RE Metropolitan Coal Modification Application (MP08_0149-Mod-4) - Longwalls 317 and 318

Attachment – WaterNSW's Concerns and Recommendations

Predicted Profiles of Subsidence, Upsidence and Closure along Tributary S due to LW317 and 318 Modification Layout

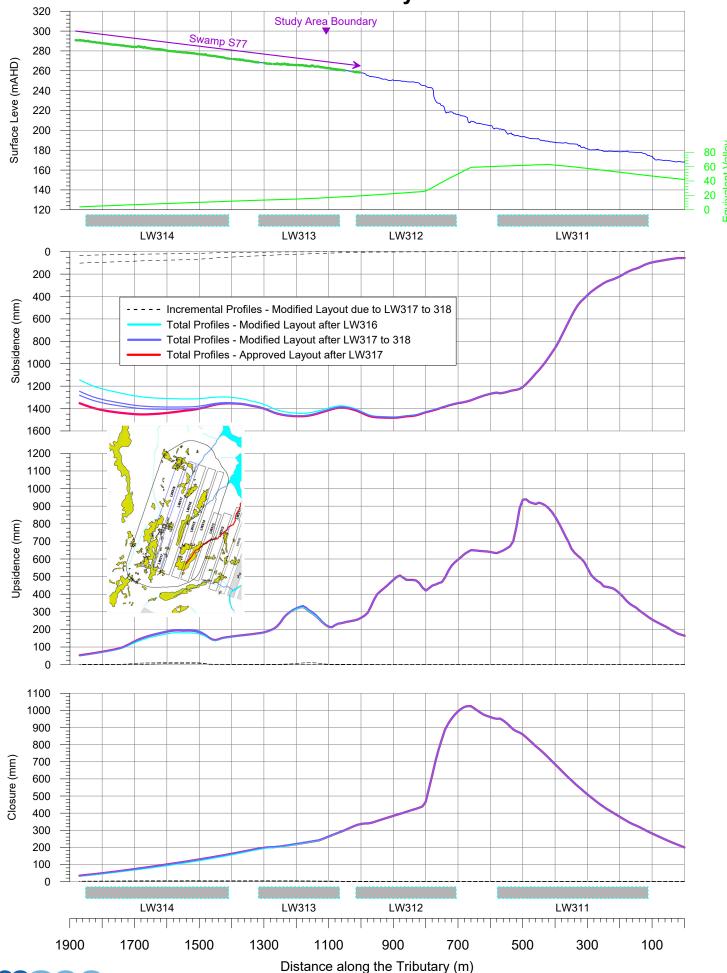
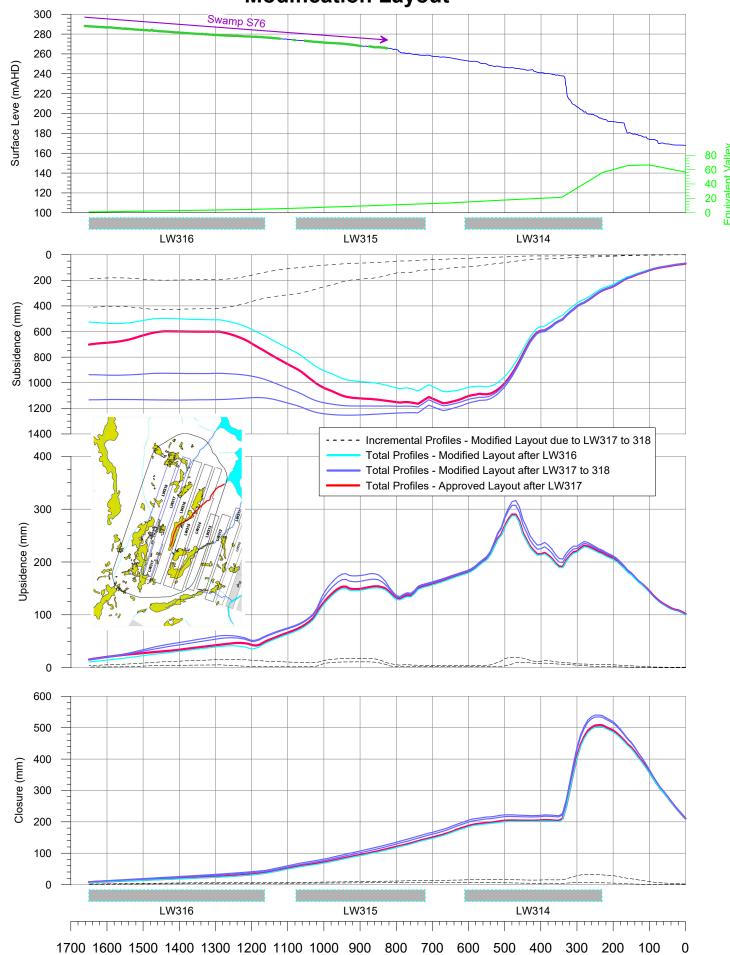
- Predicted valley closure has increased in several areas, including Tributary S (500 mm to 550 mm), Tributary U (200 mm to 525 mm), and Honeysuckle Creek (<20 mm to 350 mm). These increases present a greater risk of cracking, particularly in downstream valley sections where valleys deepen.
- Several swamps located along tributaries remain exposed to valley-related effects such as closure, upsidence, and compressive strain. However, predictions have not been provided for all potentially impacted swamps (Swamps S74 and S128 along Tributary U). Predicted mining-induced tilts are generally lower than natural swamp gradients, but in flatter areas they may still alter flow paths and swamp hydrology. The modification will result in increase in upsidence (from 150 to 175 mm) in swamp S76.

Predicted Profiles of Subsidence, Upsidence and Closure along Tributary U due to LW317 and 318 Modification Layout

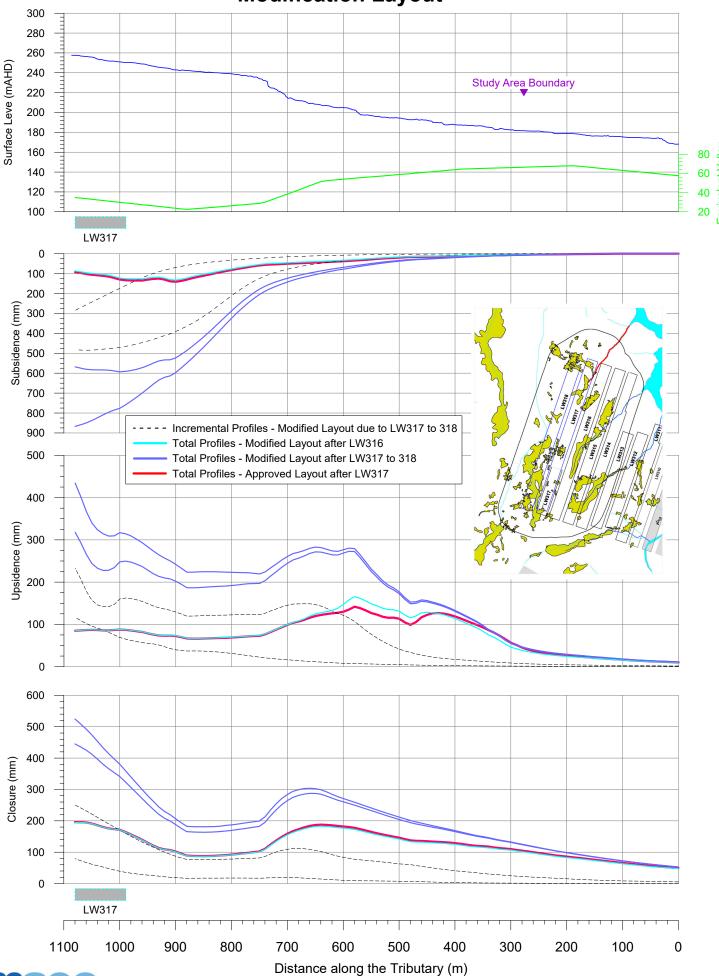
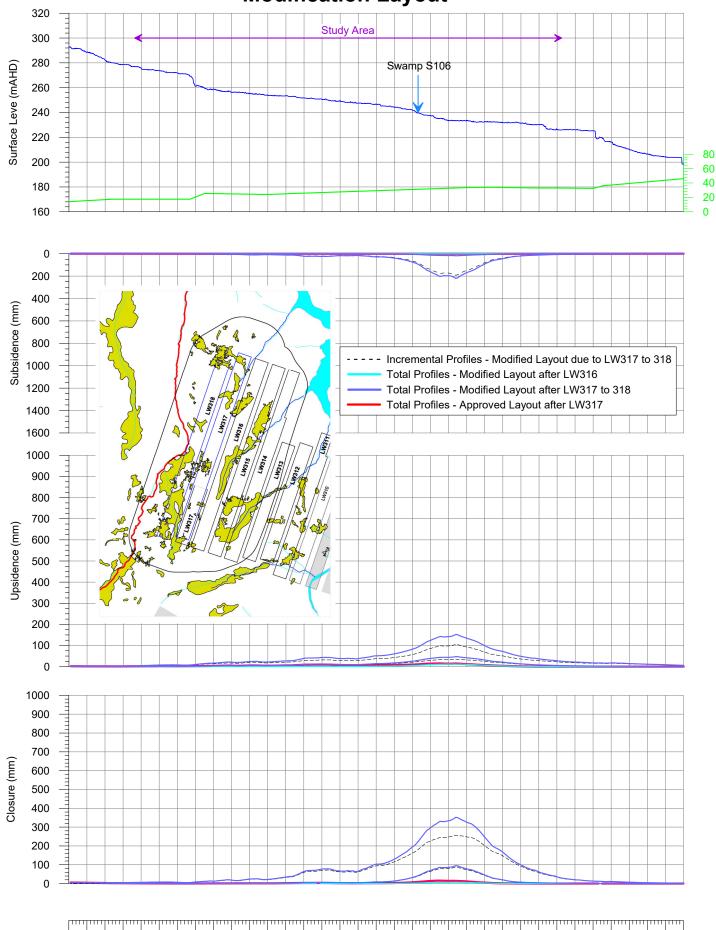
- Valley closure increases in several areas including Tributary S (500→550 mm), Tributary U (200→525 mm), and Honeysuckle Creek (<20→350 mm), raising the risk of subsidence related surface cracking, especially in deeper downstream sections.
- Six swamps are likely to experience a low but material risk of environmental consequences.
- There is increased risk of stream bed fracturing and further mobilisation of metals in Honeysuckle Creek.

- Pool water levels and iron staining should be monitored in all suitable breeding pools within swamps, Tributary U, and Honeysuckle Creek

Peabody
METROPOLITAN COAL
Relocated Ventilation Shaft 4
General Arrangement

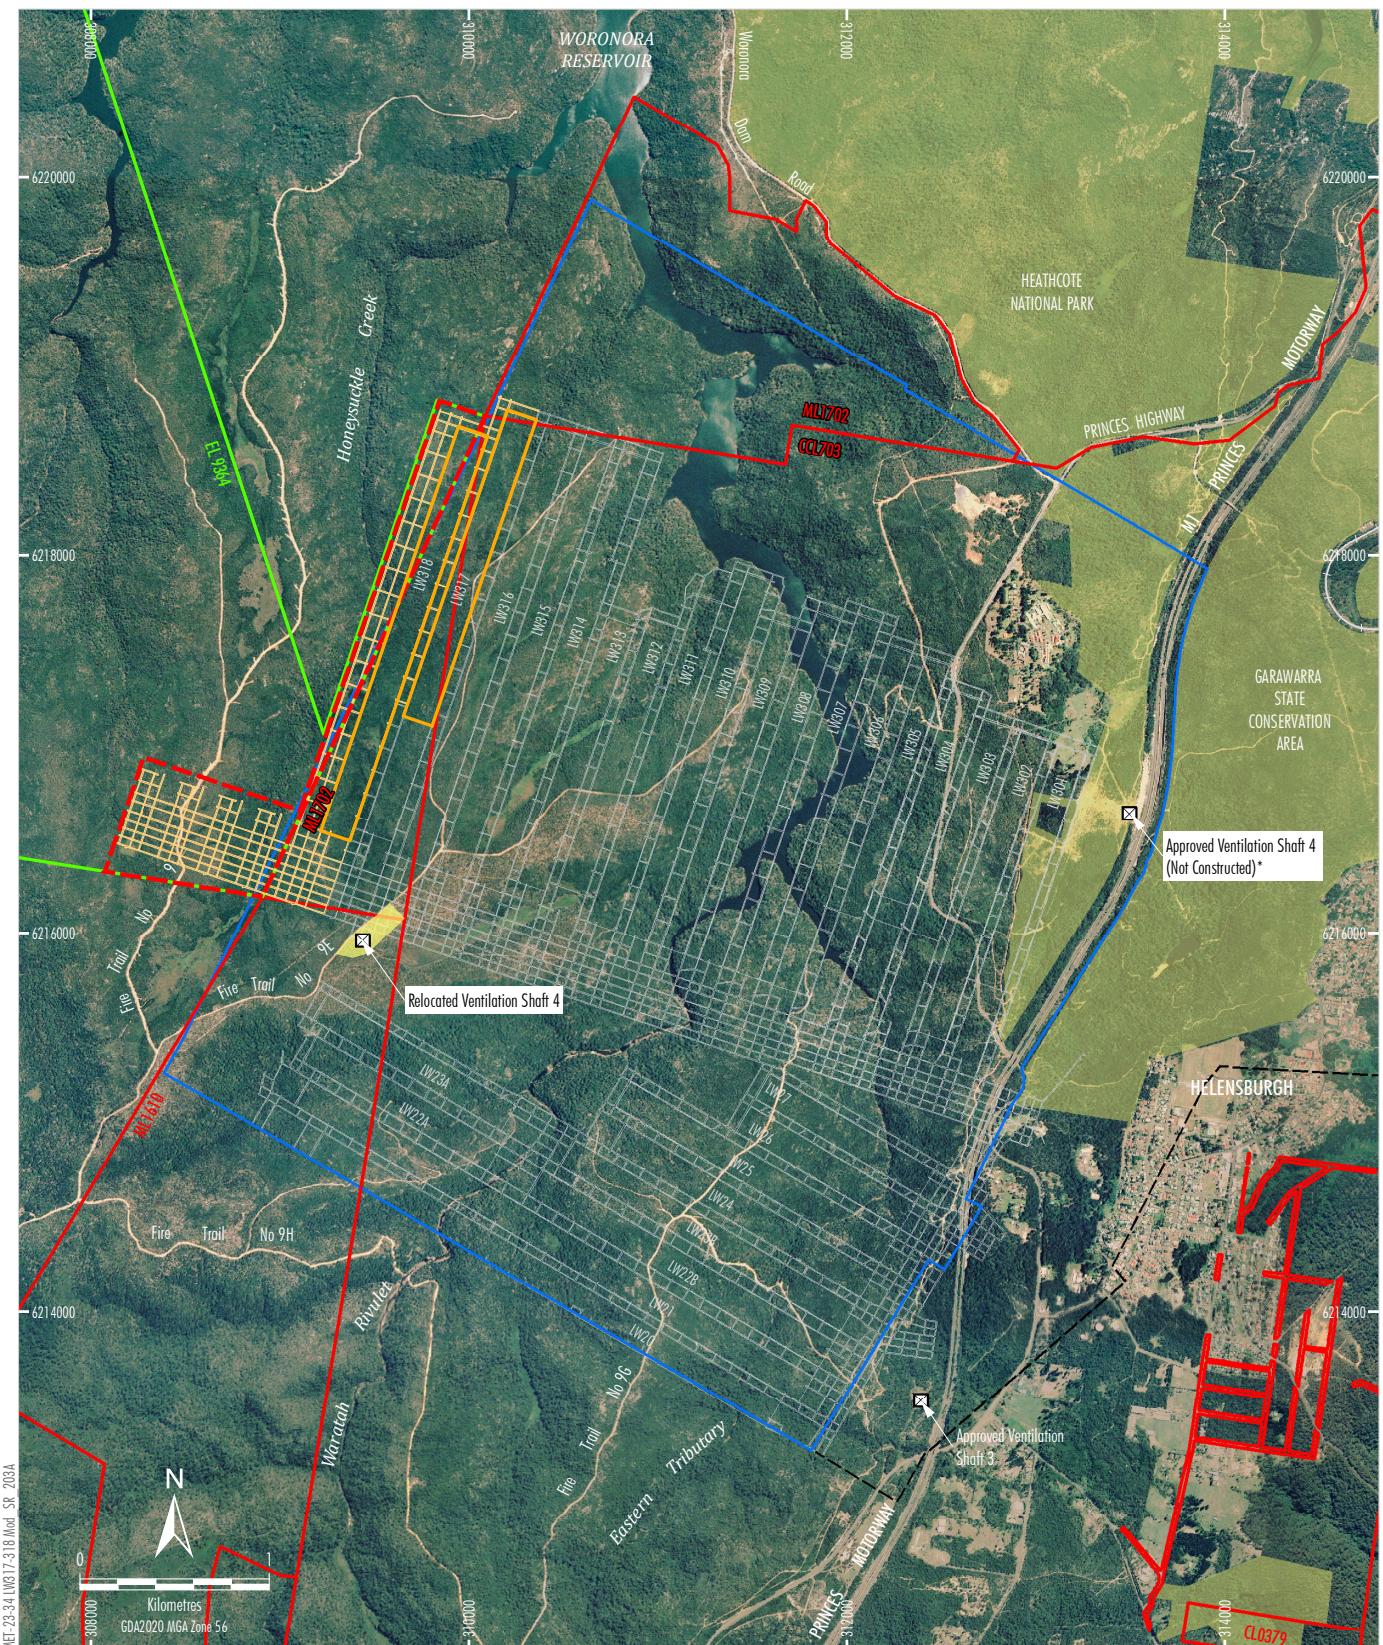
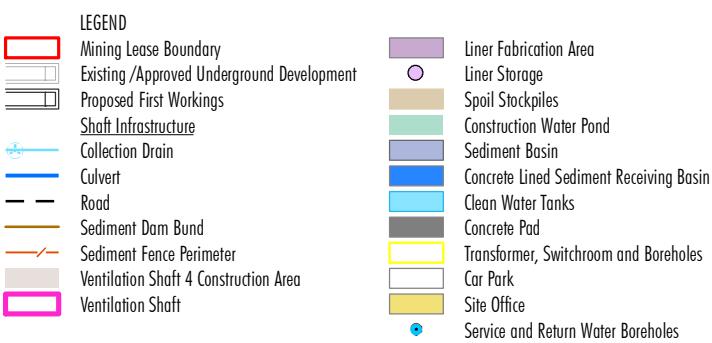
2. Relocation of the proposed shaft site should consider to increase setback from Swamp 92 and other sensitive receptors prior to approval of this proposed Modification. An assessment of potential impact of the proposed construction site should include the risk of water quality impacts, sediment load leaving site and vibration impacts on sensitive receivers.

- Water quality runoff and sediment load leaving site and impacting downstream swamps (e.g. Swamp 92) and the Woronora Reservoir.
- Potential impacts of vibrations from the construction and drilling on fauna, soils and geologic landforms have not been assessed. WaterNSW has specific concerns about if this would impact on soil compaction, especially at nearby swamps ecosystems.

2. Relocation of the proposed shaft site should be considered to increase setback from Swamp 92 and other sensitive receptors prior to approval of this proposed Modification. An assessment of potential impact of the proposed construction site should include the risk of water quality impacts, sediment load leaving site and vibration impacts on sensitive receivers.
